**Notice of Exhibition
Barangaroo – Public Domain Works (SSD-7944-Mod-1)**

Thank you for your correspondence requesting Transport for NSW to provide advice regarding the subject development application Modification 1 to SSD 7944.

Drawing Title
WATERMANS COVE
MASTERPLAN - NO TREES
Drawn
SS

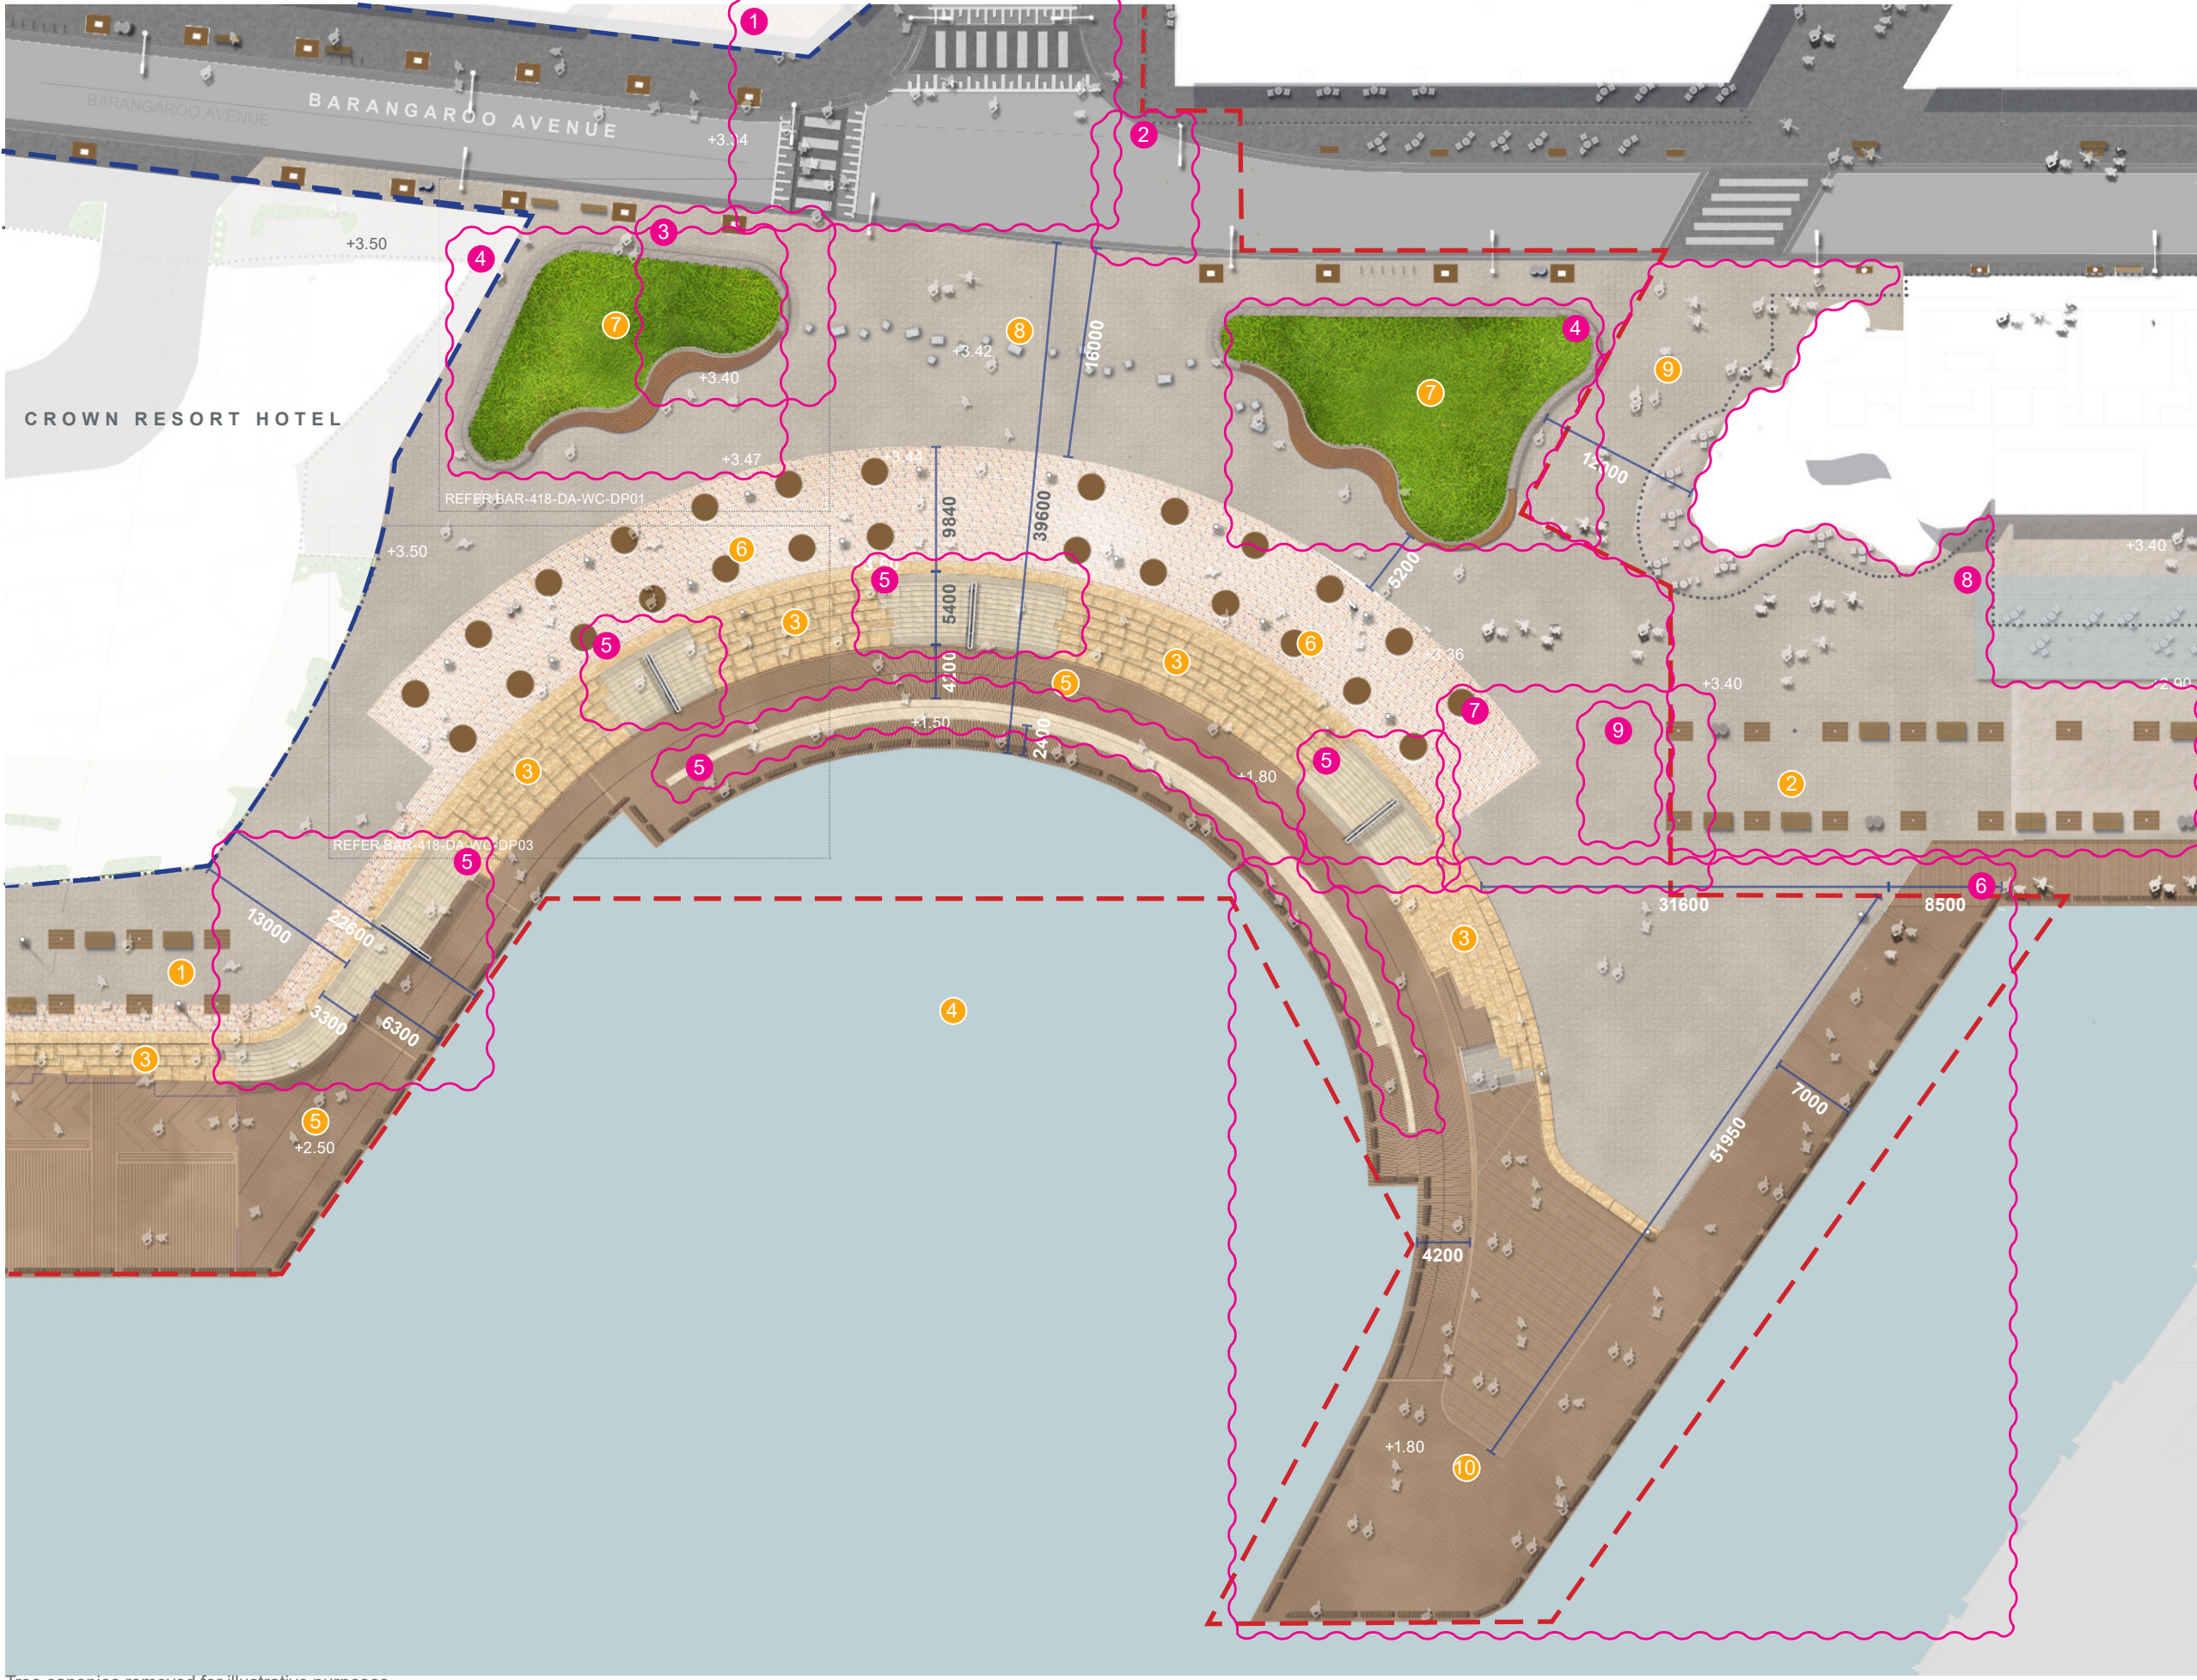
- The modification application proposes the deletion of one pedestrian crossing at the western end of Watermans Quay and Barangaroo Avenue. This may alter the design and operation of that intersection.
- The civil infrastructure report notes that a 12.5m long vehicle has been used as the standard for determining infrastructure requirements. Consideration should be given to using the larger 14.5m rigid buses as the design vehicle as they may need to use the proposed Hickson Road/ Watermans Quay and Barangaroo Avenue/ Watermans Quay intersections to access the Crown development.
- As per condition B27 of SSD 7944 development consent, it is requested that the applicant consult with the Sydney Coordination Office within TfNSW in relation to the detailed design of the intersections.
